Project Name: **AMENDMENT re entrance design;  
Bangor Savings Bank Bank/Office building with two lane drive-through**  
Project ID: #2015-080  
Address: 20 Marginal Way CBL: 113 A 025001  
Applicant: Bangor Savings Bank  
Planner: Jean Fraser

Project Name: **Bangor Savings Bank Bank/Office building with two lane drive-through**  
Project ID: #2015-080  
Address: 20 Marginal Way CBL: 113 A 025001  
Applicant: Wendy Durrah, Bangor Savings Bank  
Planner: Jean Fraser

Bank/Office Building with Bank Drive-through, 20 Marginal Way  
Level III Conditional Use and (Level II) Site Plan  
Bangor Savings Bank, Applicant  
Project #: 2015-080  
CBL 113 A025001

AE203

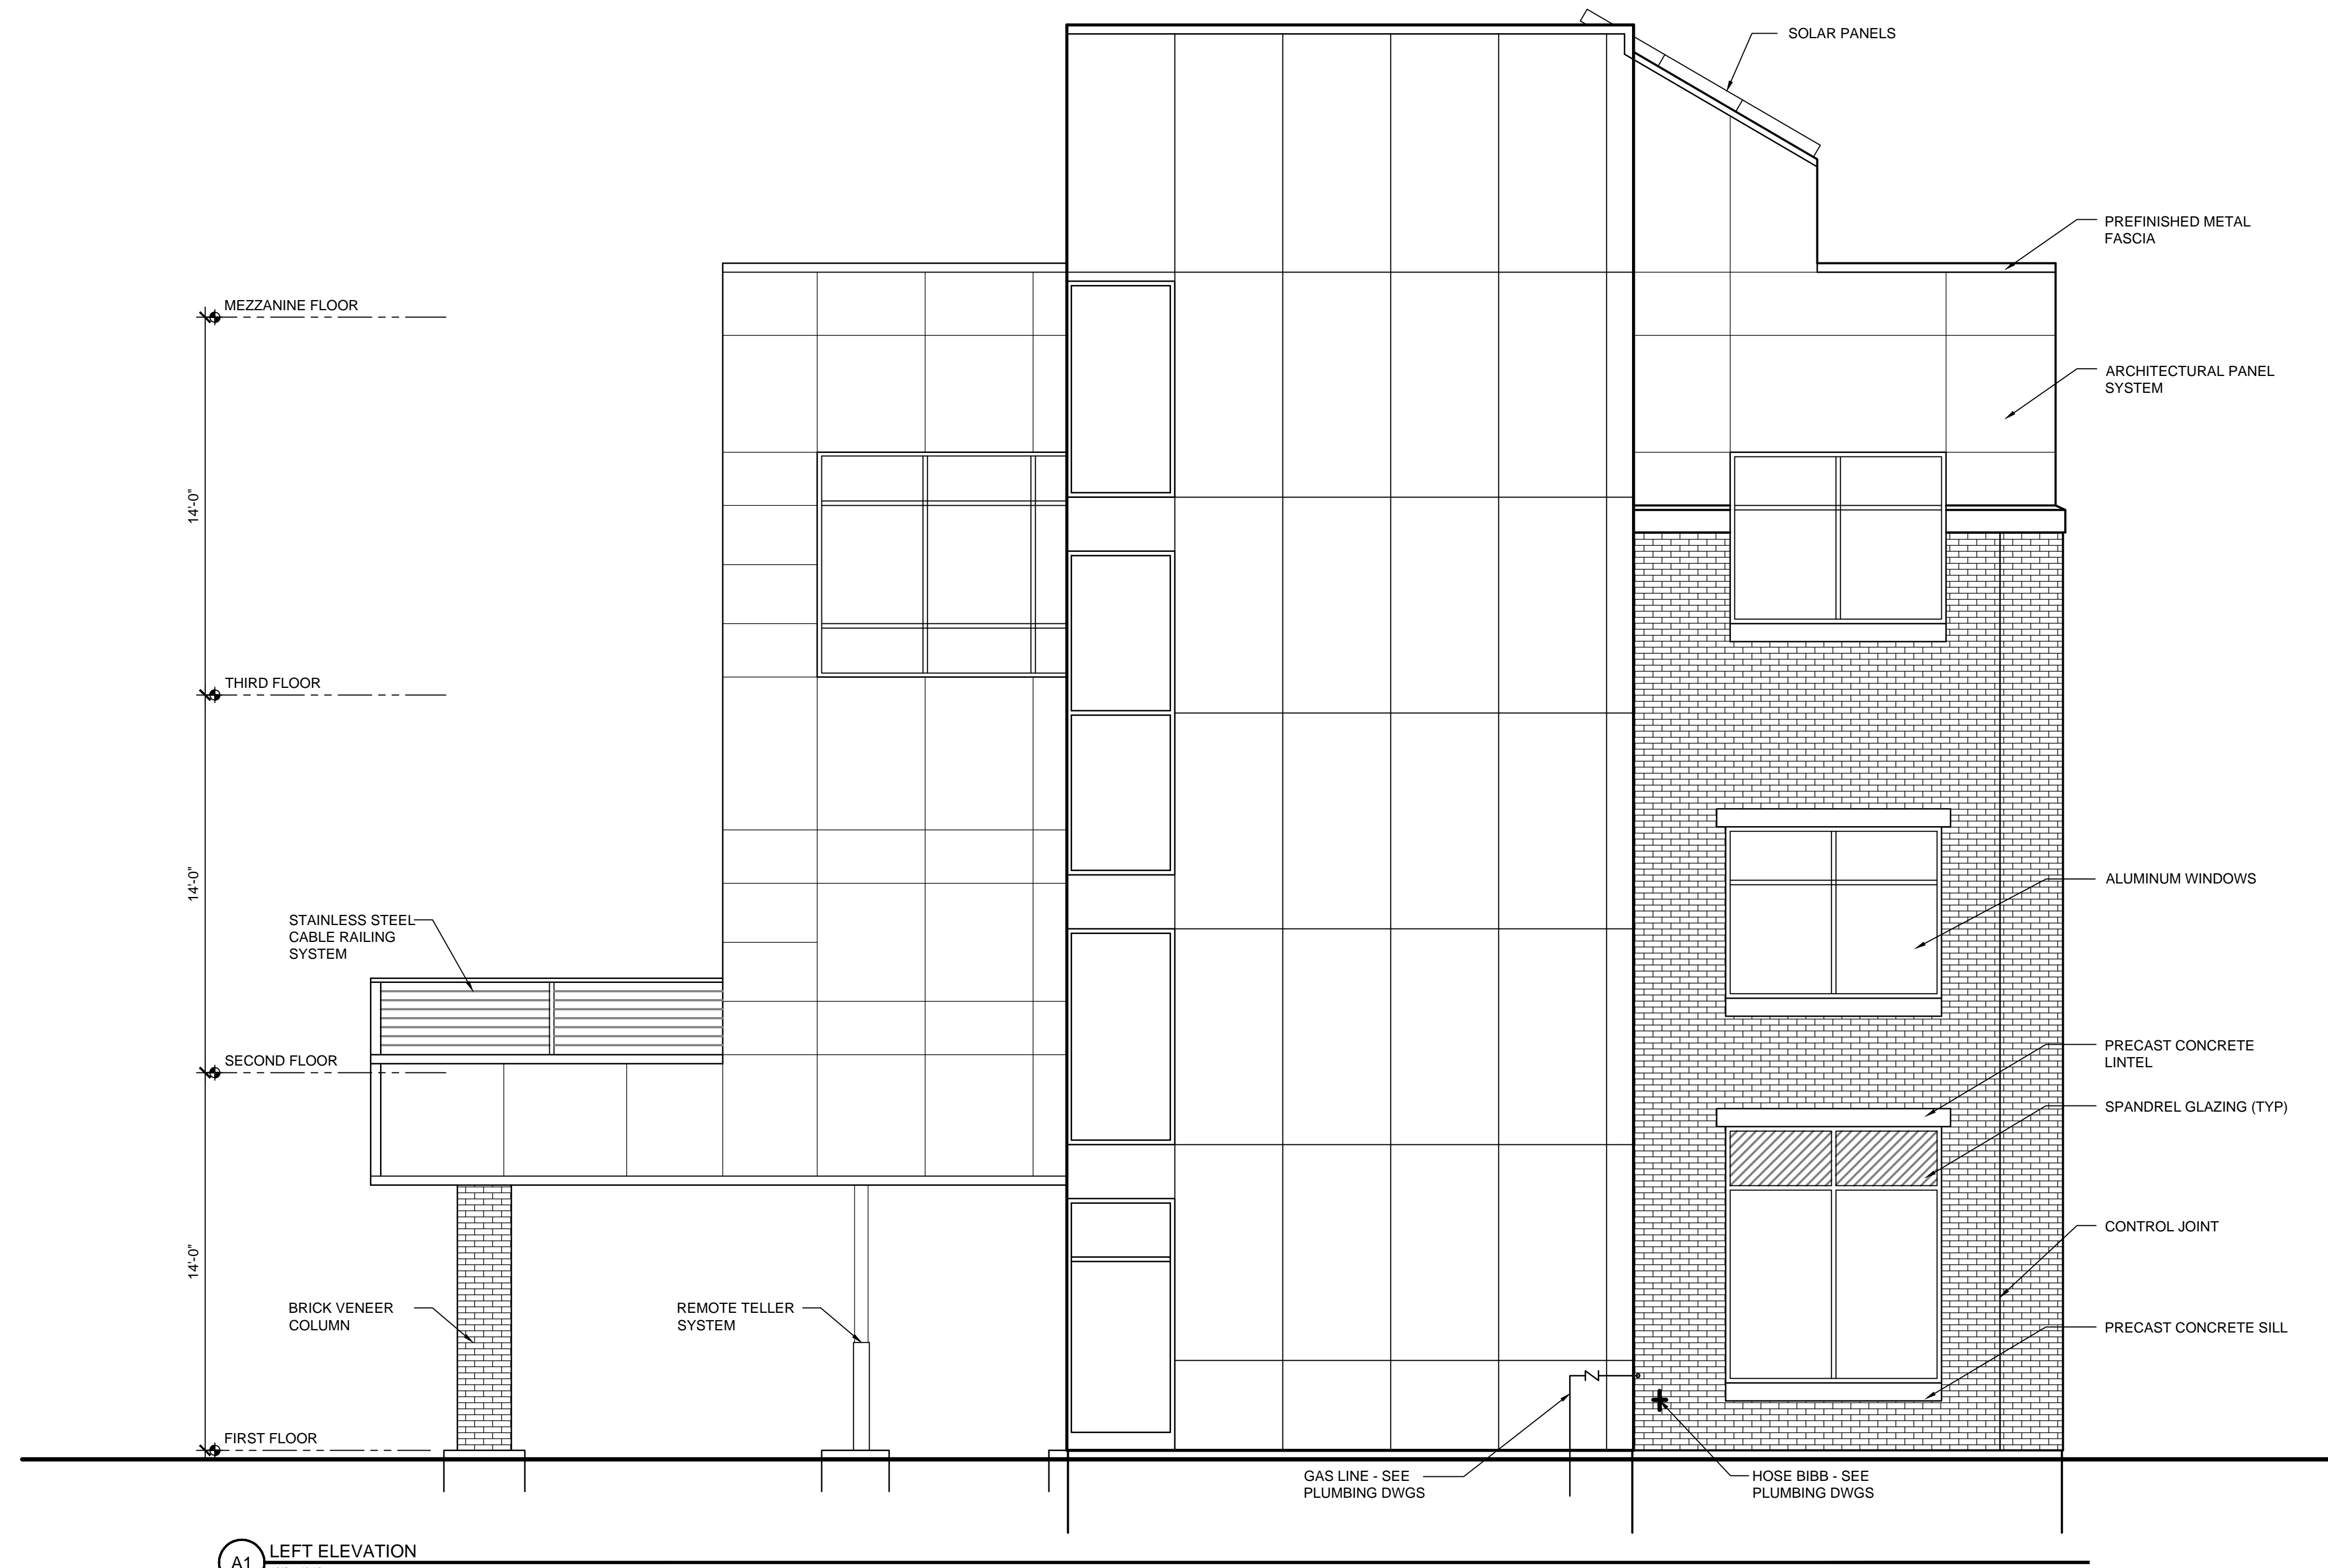
- **Proposed glass has a VLT of .56 which is lower than the allowed .7. A sample is required** before staff can assess whether the transparency is adequate.
- **Spandrel glass (opaque) is proposed** for the upper portion of the ground floor storefront which is **not allowed by the Standard**. See comments below.

- Building elevations remain the same
- Glazing for entire building shall be Solexia + Solarban 60 with a VT of .61 and which has a slight green tint. The lower Visible Transmittance and slight green tint are allowed as a compromise for better energy performance in the building and with the understanding that interior shades will not be used.
- Spandrel glass shall be used on the transom section of storefront on the first floor only (as shown in the elevations) to mask the floor plate behind.
